From: John Whittle [REDACTED]
Sent: 21 June 2017 12:03
To: Paul Cann
Cc: Anita Gardner; Paul Cleare; ben.hatt@planningissues.co.uk; mark@abmh.co.uk; Crossfield Consulting
Subject: East St/Fitzalan Rd, Littlehampton - Ref. LU/173/16/PL - Surface Water Drainage

Proposed Development at East St/Fitzalan Rd, Littlehampton
Planning Ref. LU/127/17/DOC
Planning Application Ref. LU/173/16/PL

FIGURE S-1

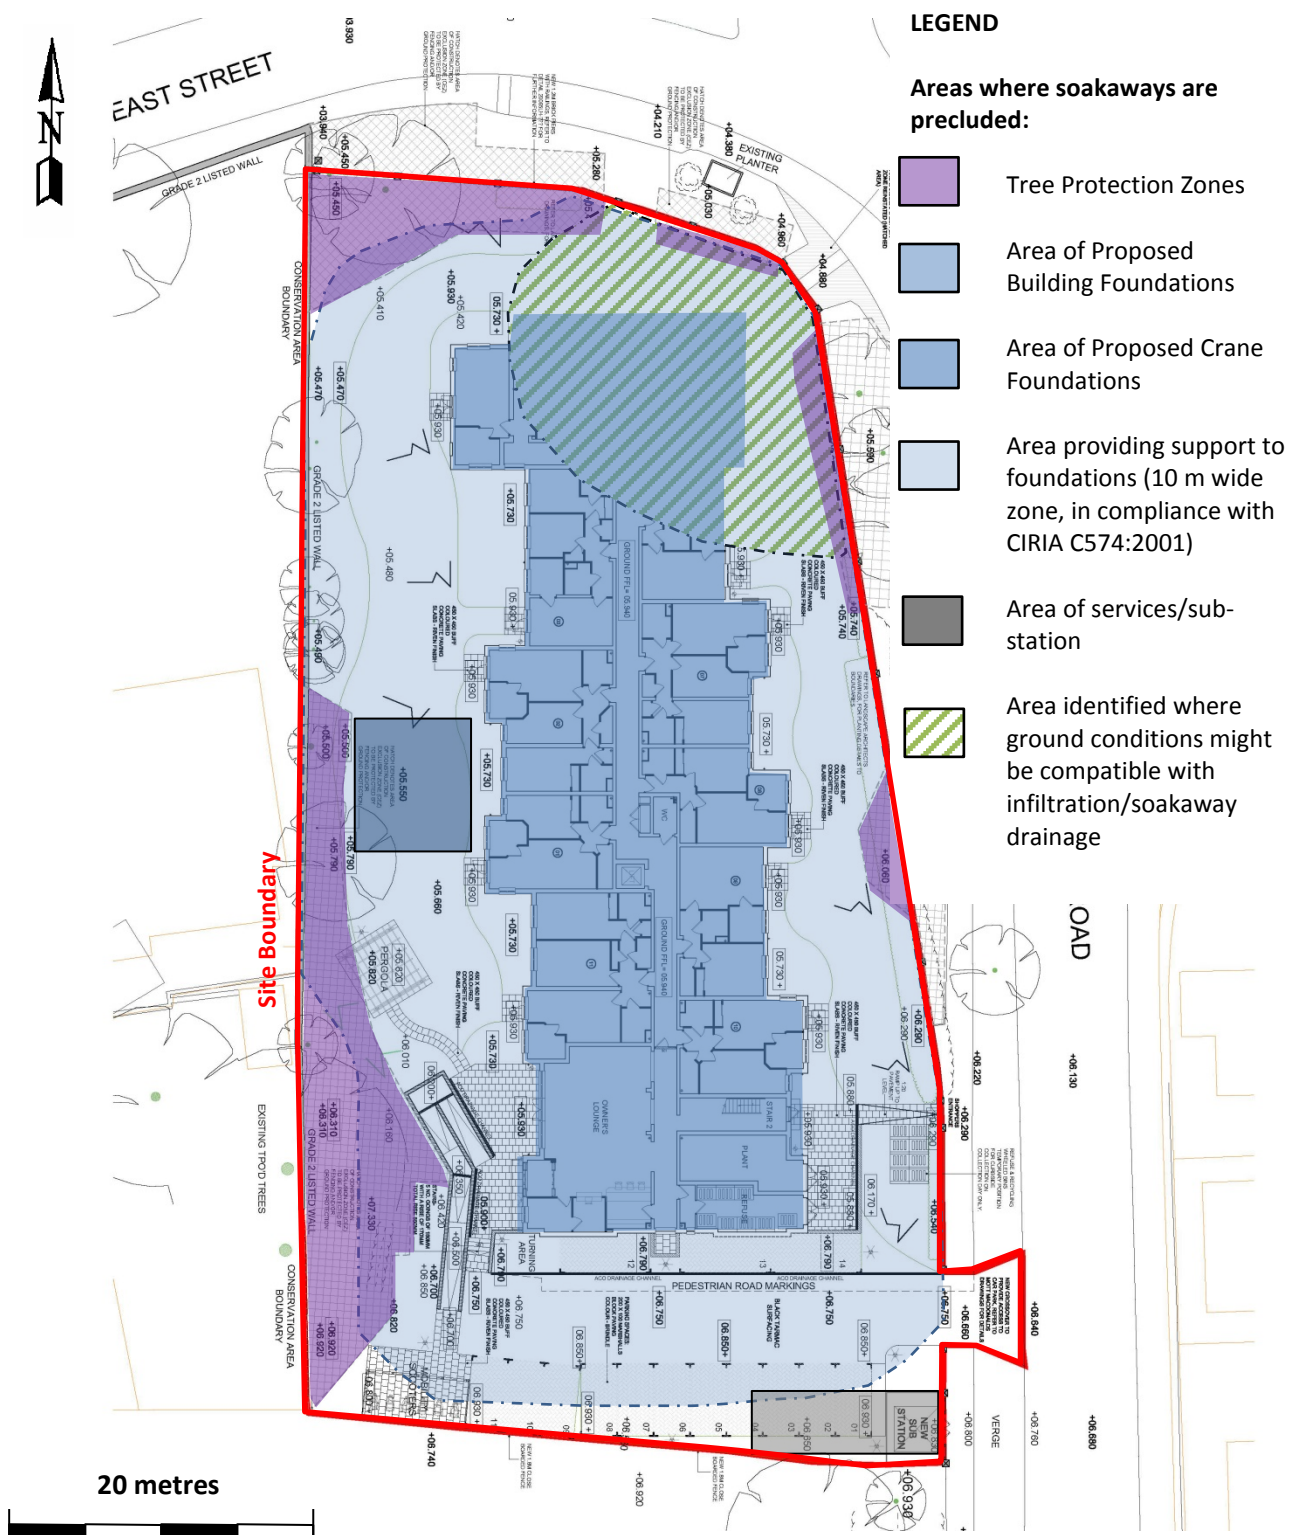
With respect to the 10m exclusion zone, Ciria C574 (clause 7.8.3) refers to 'shallow' foundations and a soakaway distance range of between 5 and 10 metres. Please also note that this particular locality is not a known area of dissolution issues. Known dissolution issues in this district are generally just north of the A27 trunk road.

Bearing in mind the above and noting that piling equipment has been seen on site, please could you provide details of the proposed foundations and explain why a 5m distance cannot be applied in this instance. Please also revise your drawing to identify available areas for soakage based upon the 5m distance. The crane platform is temporary, so should not be included as part of the exclusion zone, except where other exclusion zones overlap it.

Section 7.10 of CIRIA C574:2001 recommends in areas of low density chalk (or where chalk density is not known), *“...soakaways should be sited at least 10 m away from any foundations”* (underline added). A copy of the relevant

We concur that the crane foundation is associated with temporary works (notwithstanding, crane is associated with the most critical/sensitive foundation within the development). It is acknowledged that ground stability/support issues might be addressed by a delay in drainage construction in the area or the site required for crane support. Hence, we have removed the crane structures from the attached Figure S-2: Soakaways and Foundation Constraints.

However, omission of the crane base from consideration does not provide any additional areas for soakaways/water infiltration, as shown on Figure S-2. In particular, it is noted that the Grade II Listed boundary wall foundations also require continued support.

As apparent from the above foundation constraints (and with reference to Figure S-2), the use of soakaways is effectively precluded.
